RIBBLE VALLEY BOROUGH COUNCIL

please ask for: GRAEME THORPE
direct line: 01200 414520
e-mail: graeme.thorpe@ribblevalley.gov.uk
my ref: 3/2012/0723/P
your ref: APP/T2350/A/13/2190947/NWF
date: 07 MARCH 2013

RE – Appeal by Mr P. Snaith and Mr L. Shaw against the refusal to grant planning permission for the demolition of an existing stable block in order to erect 2 no. two-storey, four bedroom detached houses and a garage block on the site of a former stable, Trapp Lane, Simonstone, Lancashire, BB12 7QW.

proposed elevations

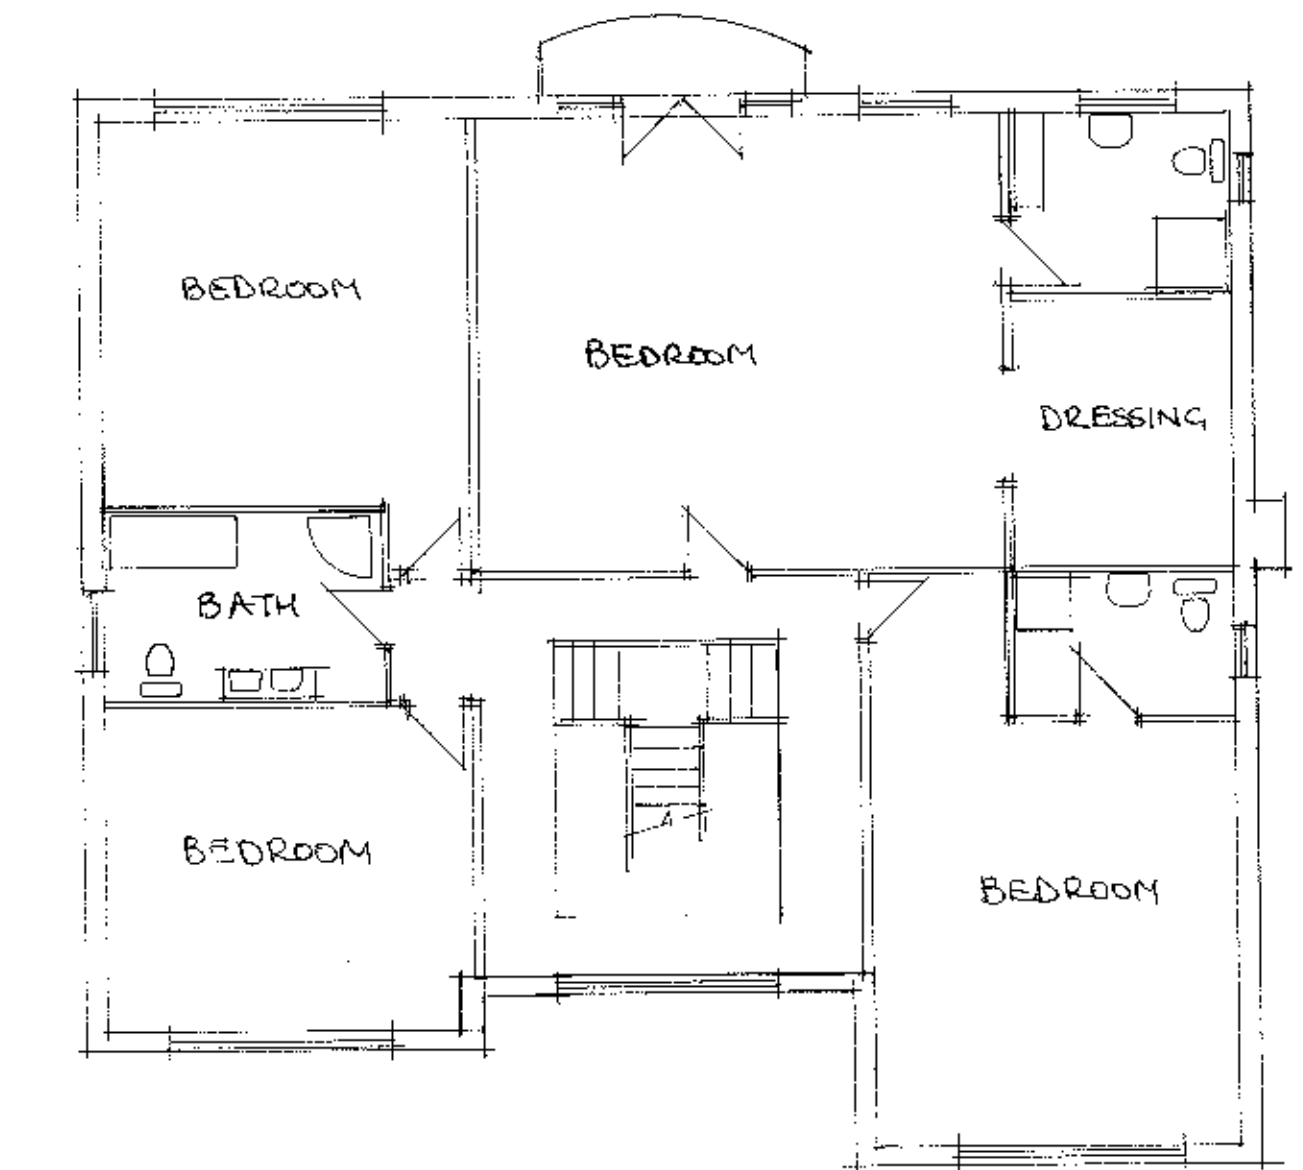
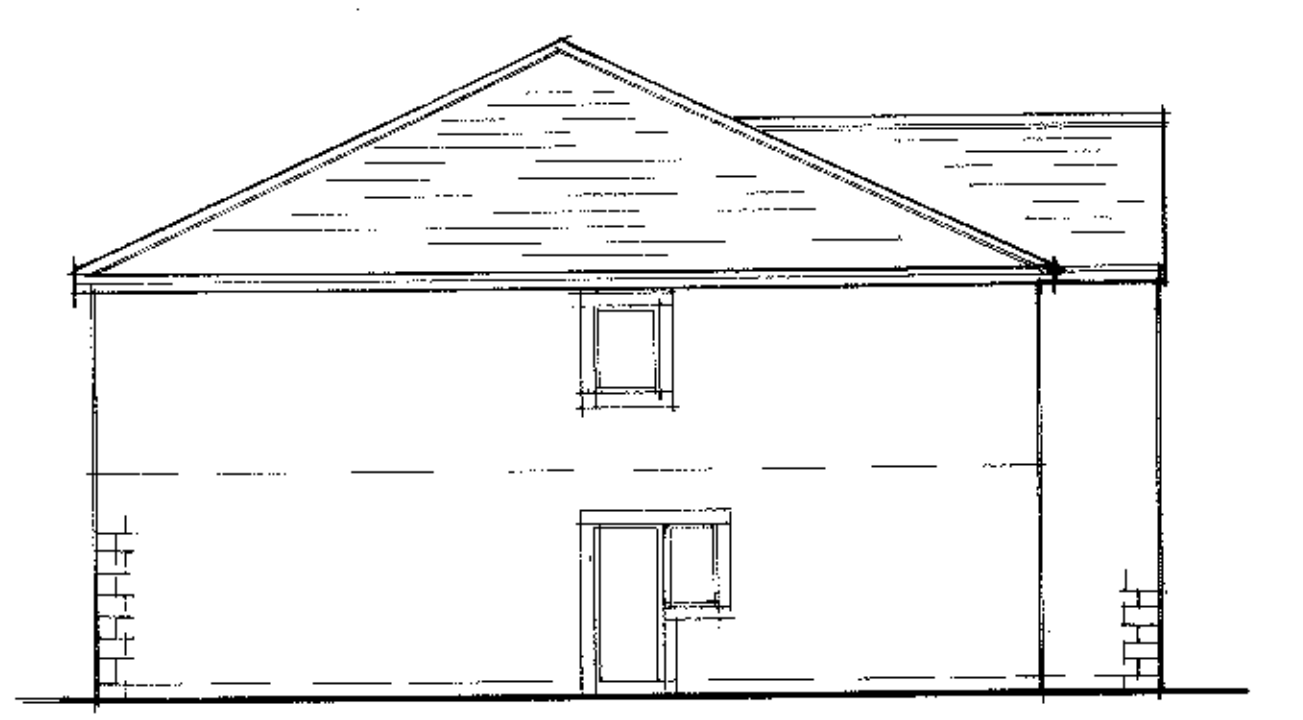
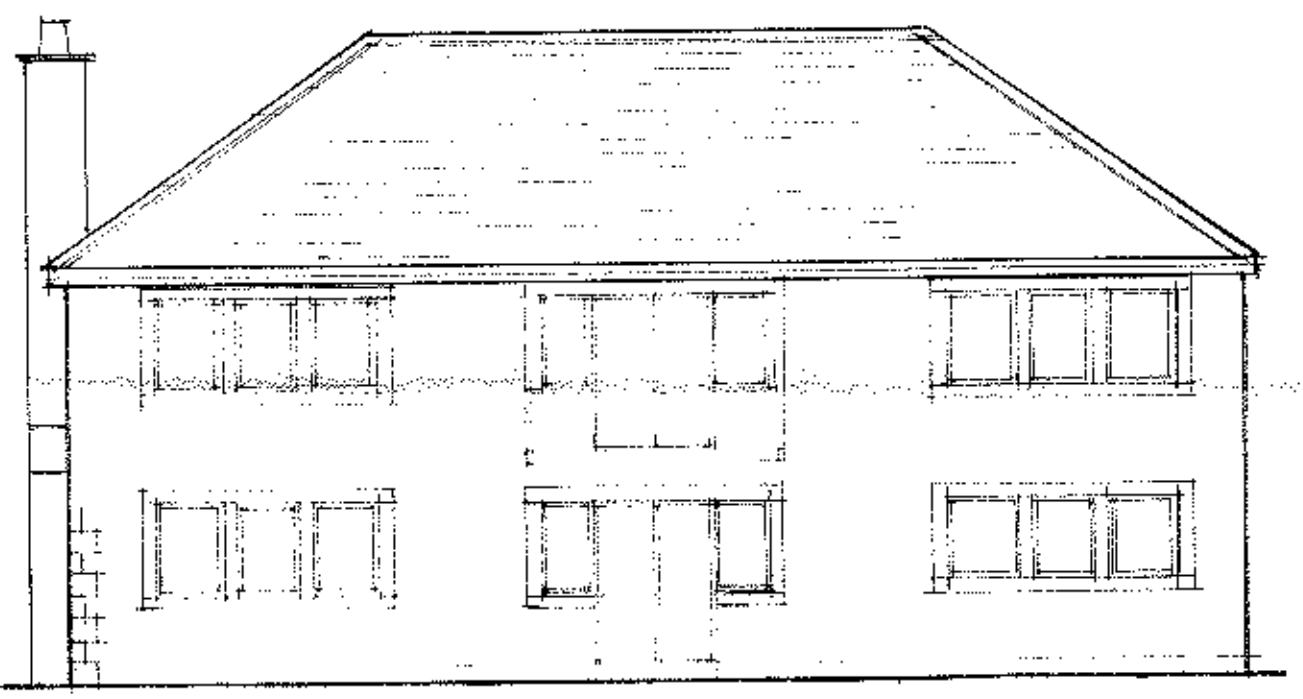
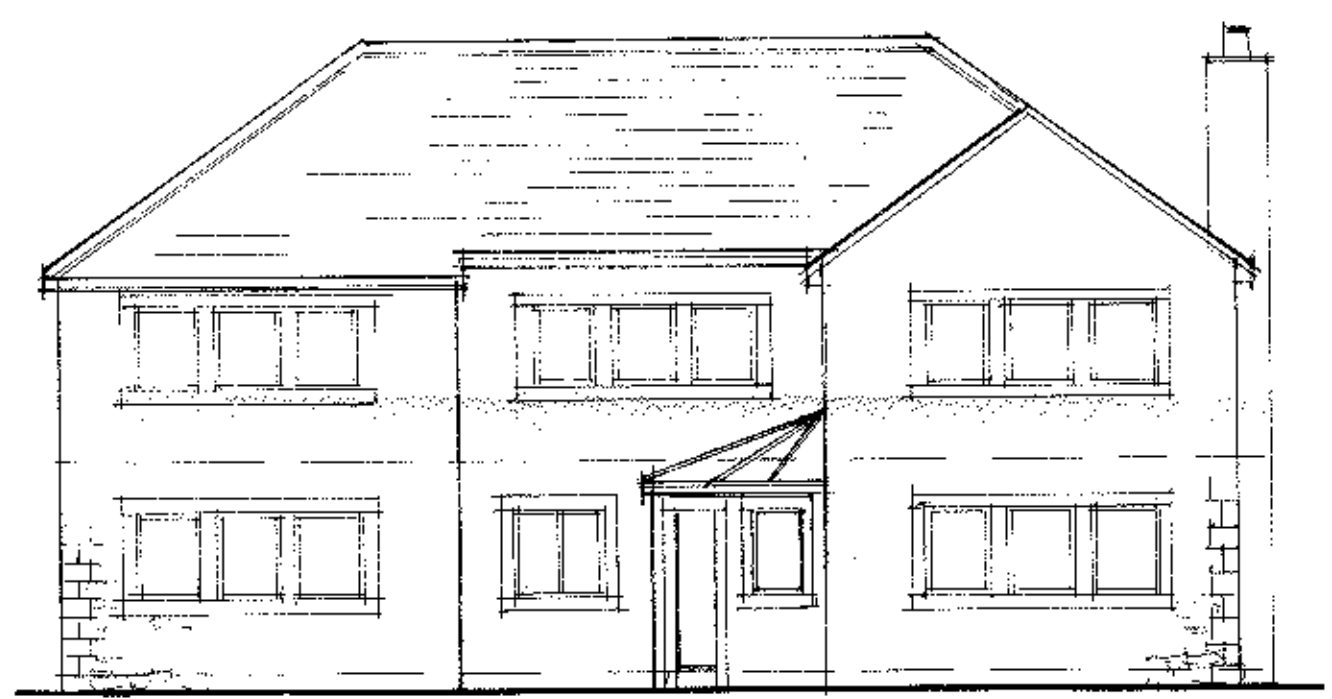
This Policy is considered to support all three reasons for refusal, based on the dwellings proposed not being to a high standard of building design, the scheme not being sympathetic to existing and proposed land uses on the basis of the dwellings scale, massing and features, the impact on the amenities of the occupiers of the adjacent properties and the subsequent adverse visual impact on the character, setting and appearance of the locality to the visual detriment of the area.

- 3.9 With regards to Ground 12, the pre-application advice given in April 2012 highlighted the view that 'From the sketches submitted with the enquiry, the house types and design details would be wholly out of character with the rural nature of the area. The drawings depict houses that are entirely urban in character.' A simple change in materials would not automatically ensure that the scheme would be acceptable as the overall design and house type proposed remains inappropriate. The Council would not accept a condition only relating to details of the siting, design and external appearance being agreed in writing for two reasons. The Council do not feel this could control sufficiently the scale of development on site, a fact is supported by the proposed development being described as 'two-storey, four bedroom detached houses and garage block', and that the visual impact of any scheme on this site is vital when considering the principle of the development of the site, i.e. it would not accord with paragraph 14 of the NPPF, granting permission unless any adverse impacts of doing so would significantly and demonstrably outweigh the benefits. Without a full visual assessment of the scale and landscaping proposed (along with the other matters above) for a scheme on site, there is no way of accurately considering the benefits of a scheme and its impacts.

- 3.10 With regards to Ground 13, given the elevated position of this site in relation to neighbouring properties and the fact that two-storey properties are now proposed, not the conversion of a single storey building, the Council consider the third reason for refusal to be valid.
